**B9 Paper Mill**

Orora

**Submission Report - Modification #5**

29 May 2015

Figure 7: Proposed relocation of existing driveway

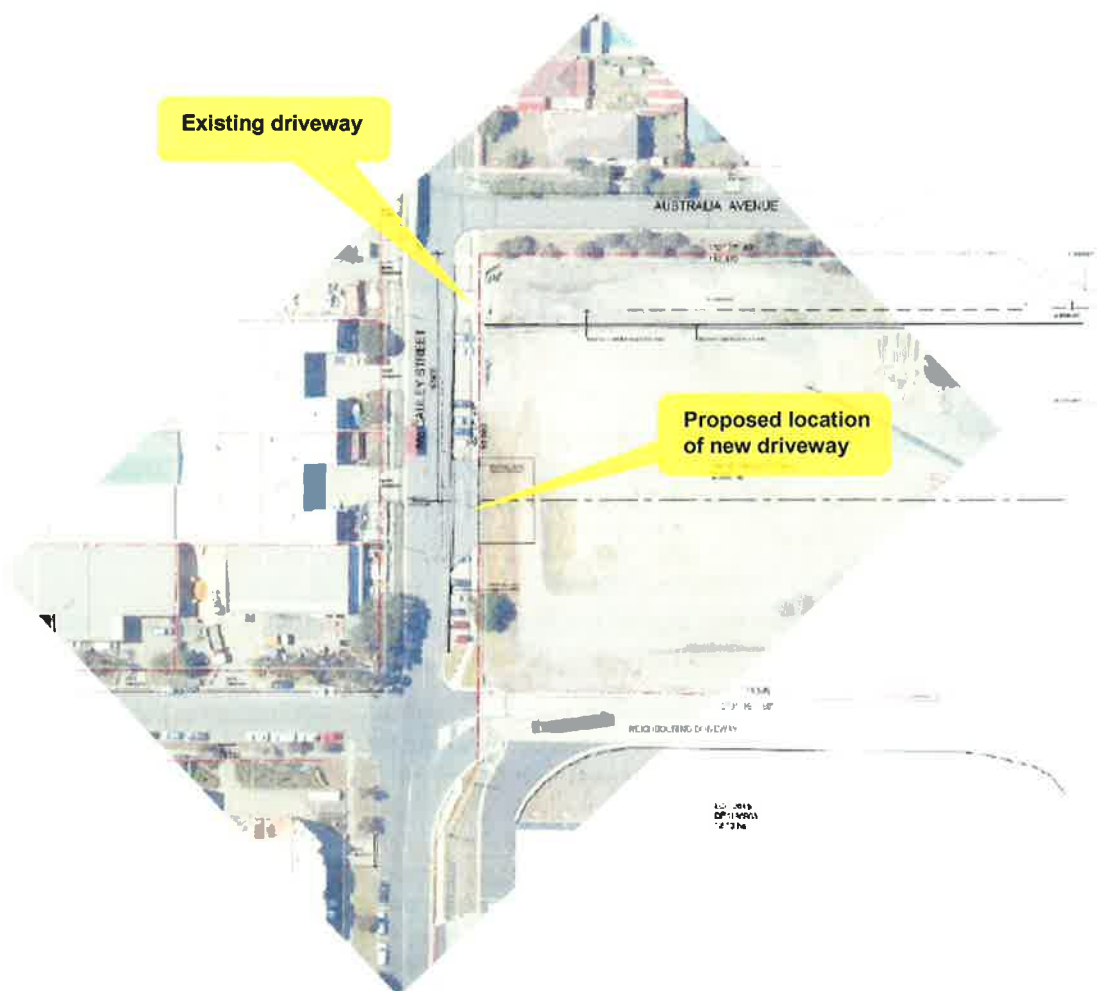
RCC has objected to the relocation of the access on McCauley Street, citing that the proposal to relocate the access is primarily a means of addressing issues associated with a Complying Development Certificate issued for the proposed redevelopment of Lot 2014. RCC state the CDC has been issued illegally as a Section 138 approval under the Roads Act for the relocated access had not been obtained before the issue of the CDC.

RCC have also stated that the Orora's main McCauley Street access should be used to access to Lot 2014. While this was originally intended, the nature of the proposed new development of Lot 2014 poses significant issues. This includes:

Orora has sought the relocation of the access for operational reasons— rather than to remedy any issues with a planning approval. The developer of the McCauley Street precinct has obtained legal advice regarding this issue and it is included in Appendix A.

- the Orora access is currently one-way (ie exiting site on to McCauley Street). Considerable works would be required to make the access two-way especially to allow for semi-trailer movements to and from Lot 2014.

- The traffic from Orora's site using the McCauley Street exit road is all heavy vehicle traffic including B-Doubles – whereas the traffic accessing Lot 2014 will be predominately cars and light vehicles. This would present a significant road safety risk at the intersection of the two site exit/entry locations on the potential shared access. From a road safety perspective it would be preferable to separate the two sources of traffic.

- With a shared access site security for Orora would be substantially harder to maintain. The existing security gates and fencing would need to be relocated and there would be a greater risk of non-Orora vehicles and personnel entering Orora's site due to the proximity of the two accesses.

Consequently having a shared access for the Orora and the new development on Lot 2014 is not practical and may result in additional road safety issues.

**Figure 10:** Predicted night-time noise levels from operation noise with interim noise mitigation works

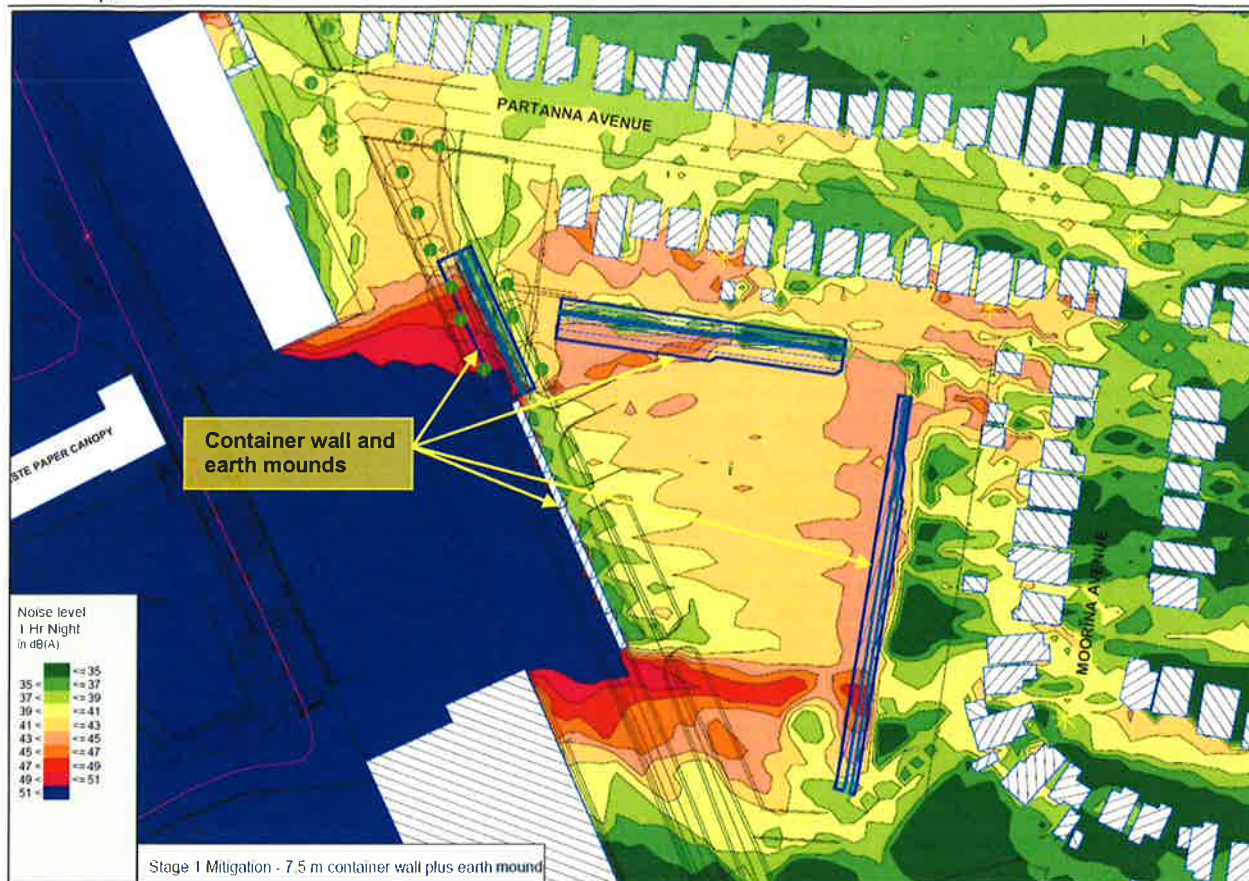
<p>Additionally, the EPA is concerned that the community will be subject to elevated noise levels during the period between removal of the B7 building and completion of the noise wall (if this is found to be feasible). Accordingly, the EPA requests that a clear timeframe is provided for the noise wall survey and feasibility studies, additional noise monitoring and Noise Barrier Design Plan</p>	Section 4 - Noise
<b>Community #1</b>	
Requests that the noise wall be constructed before the demolition of B7 building commences to mitigate demolition noise and dust – as well as providing operational noise mitigation.	Section 4 - Noise
Requests that the existing noise wall be extended along the boundary of the site from Australia to Botany Road	Section 4 – Noise
Requests that the brick wall along Purcell Park be rebuilt as soon as possible to mitigate visual impacts	Section 5 – Visual

To mitigate the impacts of demolition noise and to provide noise mitigation for sensitive receivers between the removal of the B7 building and the construction of the final noise walls, Orora is proposing an interim solution.

To further reduce the direct noise emissions from the Orora site, additional container walls would be installed on the Hanger Block, adjacent to the Ausgrid easement. The positioning of the containers in this location indicates a direct reduction of operational noise from within the site.

The combination of noise mounds and container wall would be an interim solution until the final noise wall is constructed. The interim solution would not achieve Orora's noise criteria at all sensitive receivers, however, would provide significantly better noise mitigation than no interim noise mitigation as was proposed in the Modification Report. Predicted noise levels at relevant sensitive receivers are presented in Appendix B – Stage 1.

**Figure 11:** Predicted night-time noise levels from operational noise with final noise mitigation works

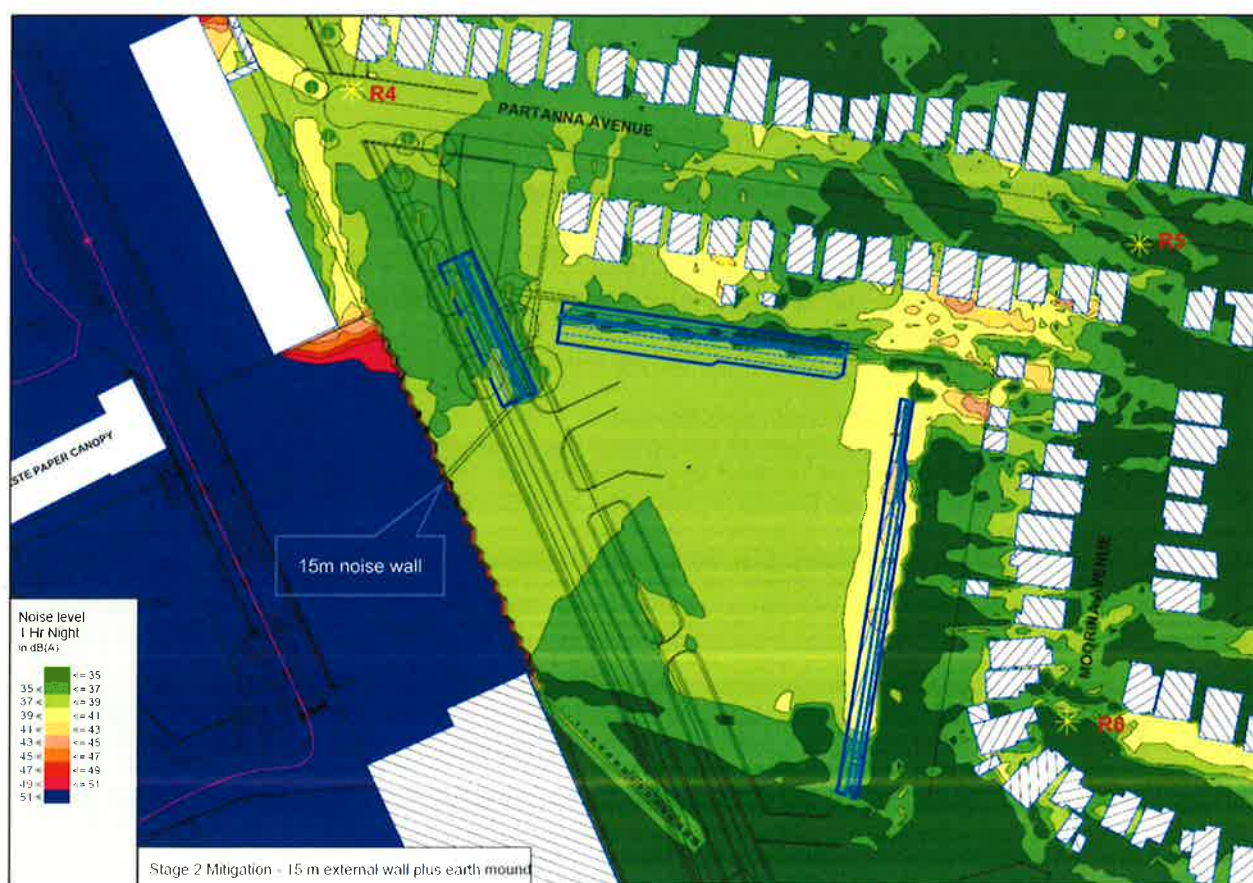
The submission from the EPA raised concerns about the period between the demolition of the B7 Building and the implementation of final noise mitigation measures – and also about the form of the final noise mitigation measures including the impacts of road and port noise on sensitive receivers.

The permanent noise mitigation solution has considered the location and height of noise walls and mounds required to meet Orora's operational noise criteria.

The final noise mitigation would consist of an up to 15 m high noise wall on the boundary of Orora site with the Ausgrid easement and retention of the noise mounds (or a similar structure) on the Hanger Block. The 15m noise wall would generally be located in the gap created by the B7 buildings operation. Further modelling would be undertaken to determine the optimal noise wall height once the extent of impacts can be confirmed. Due to the close proximity of the noise wall to the B7 building and the associated risk of damage during demolition, it would not be possible to construct the noise wall before demolition commences.
